KITTITAS COUNTY COMMUNITY DEVELOPMENT SERVICES

RE: Kohl Boundary Line Adjustment (BL-17-00015)

MEMORANDUM

TO: All Staff
FROM: Justin Turnbull, County Surveyor 
DATE: August 23, 2017
SUBJECT: County Survey Review of Boundary Line Adjustment 17-00015 (Kohl)

BOUNDARY LINE ADJUSTMENT
 PREPARED FOR
 PETER KOHL
 A PORTION OF THE SW 1/4 OF THE NE 1/4 OF SECTION 4,
 TOWNSHIP 19 NORTH, RANGE 15 EAST, W.M.

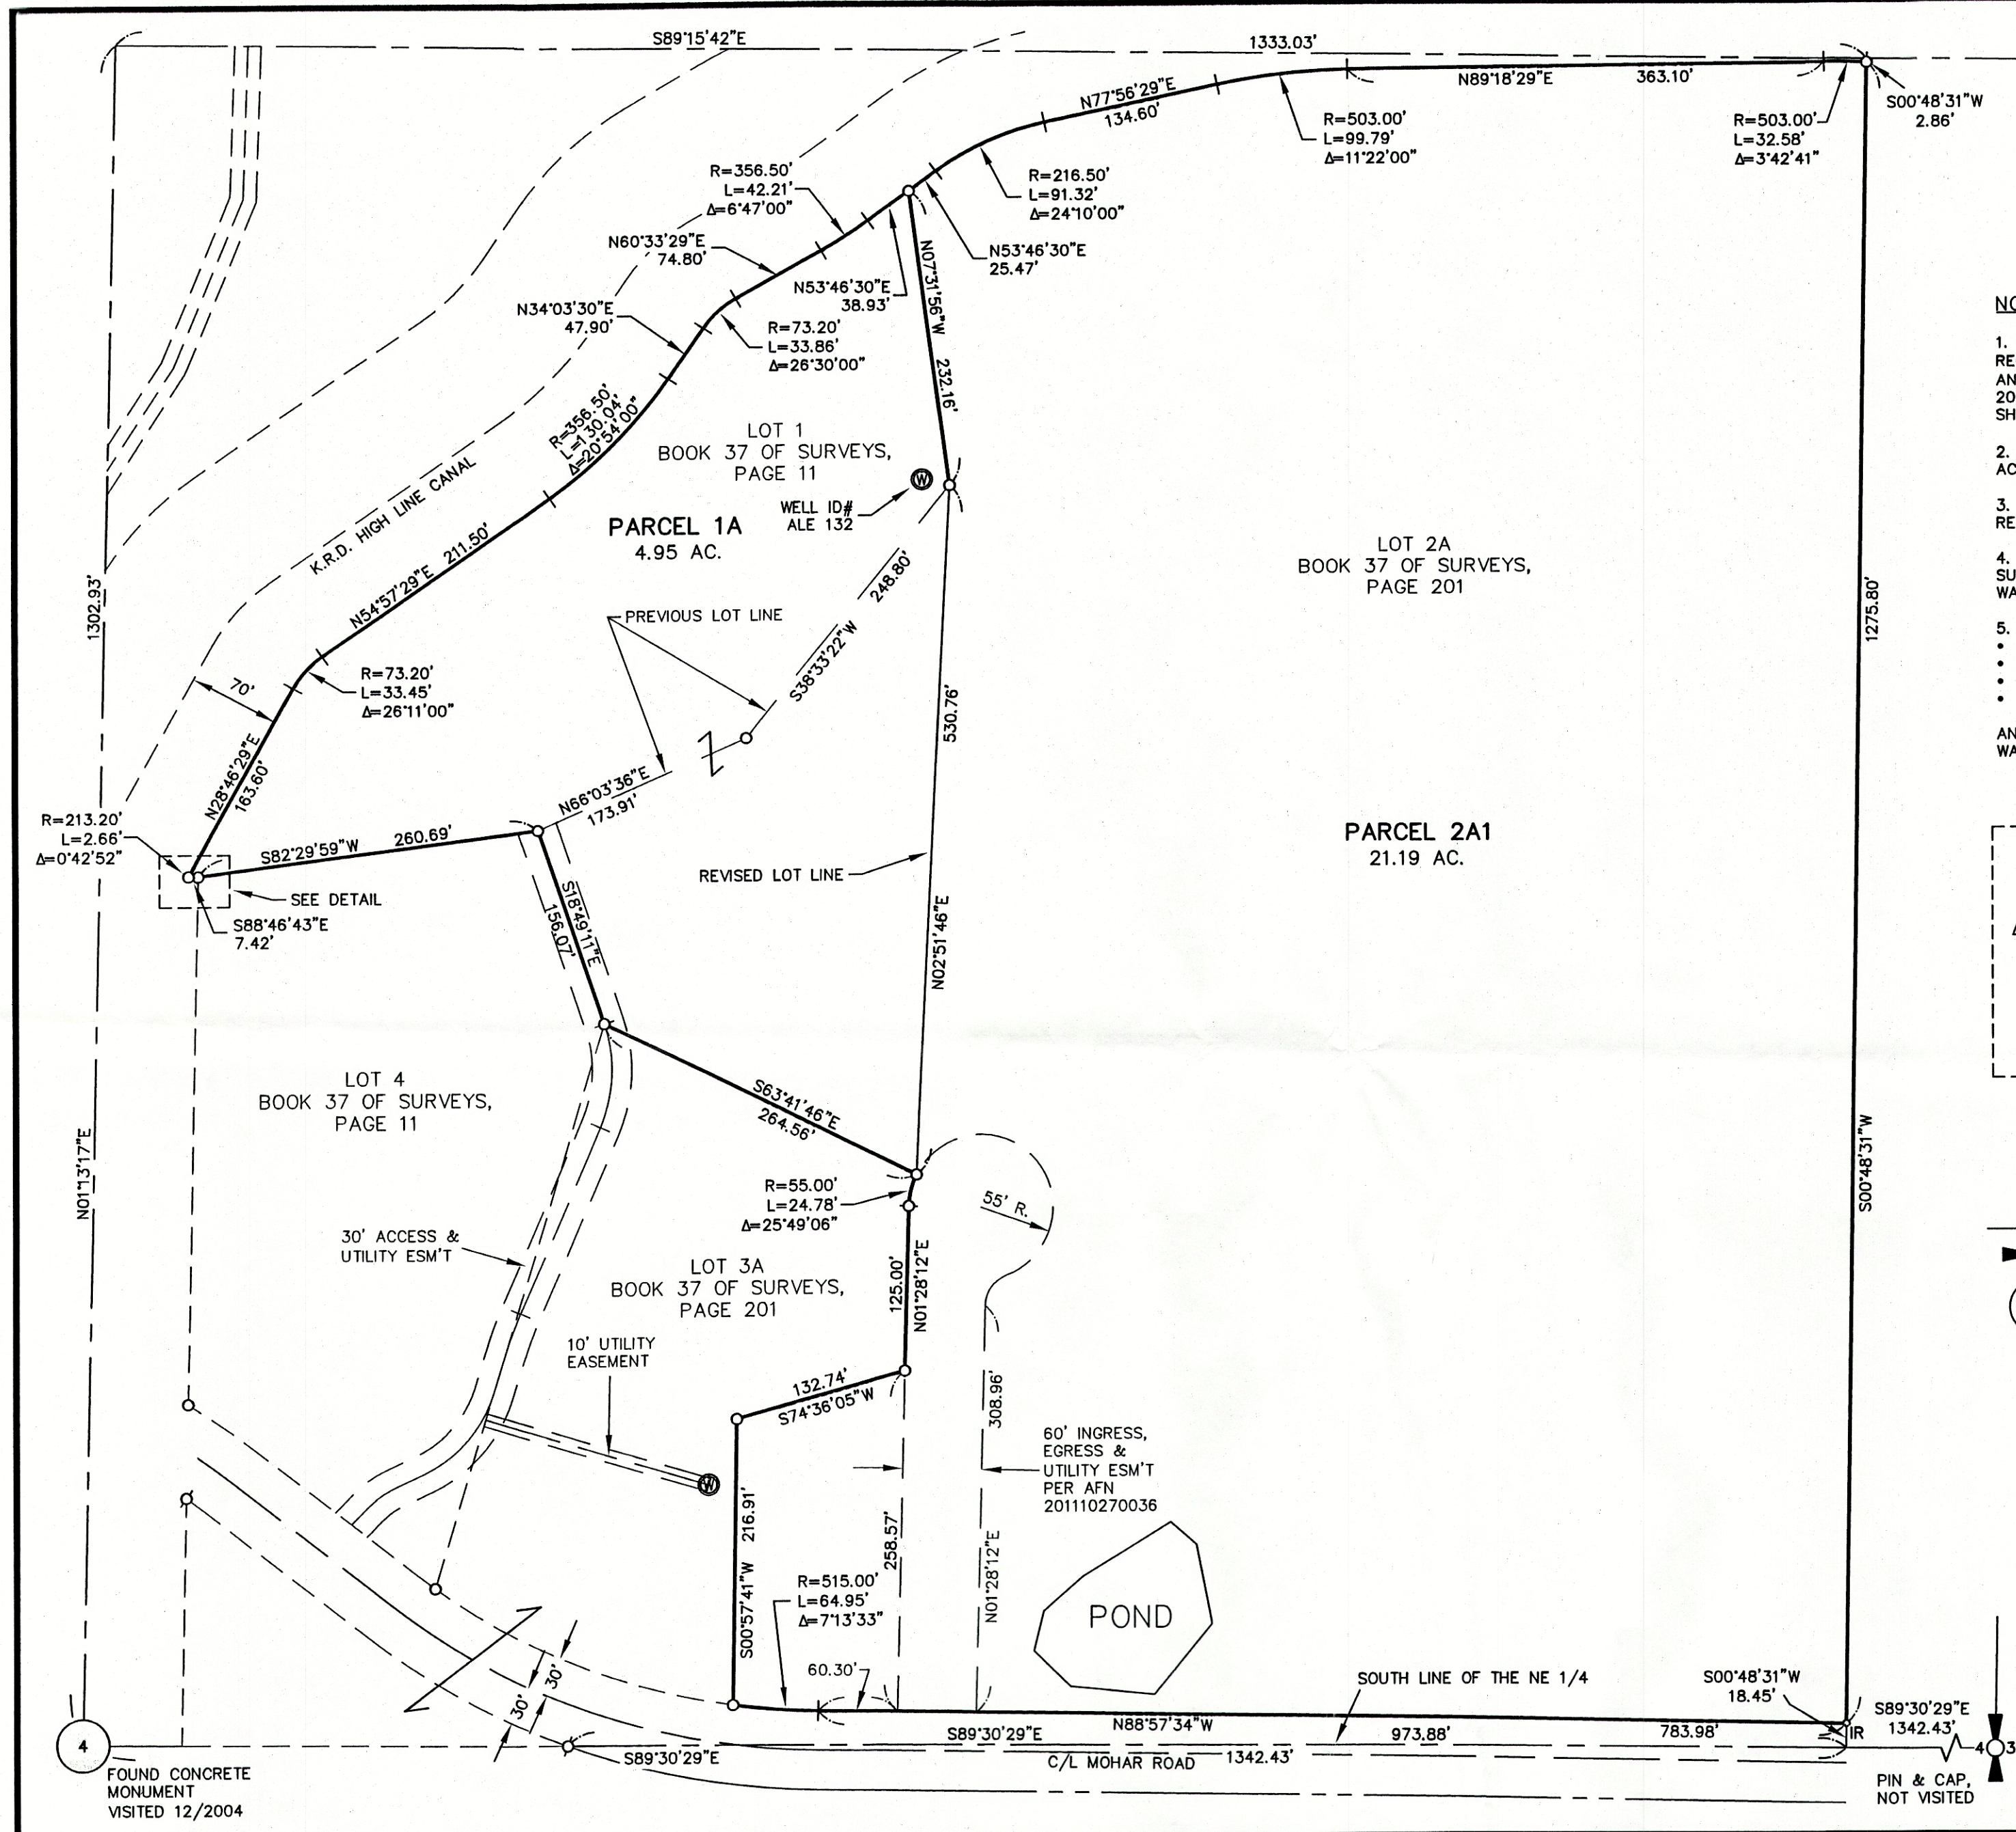
1. Roadways should include name, width, ownership (private/ state/ county) surfacing material and R/W or easement. (EX: Mohar Rd. – 60' County R/W – Paved)
2. Easements should include recording number. In the absence of record documents, include a note detailing the surveys of record identifying the easement, to substantiate any prescriptive rights.
3. Please include the LS Number of "Found Iron Rod & Cap"
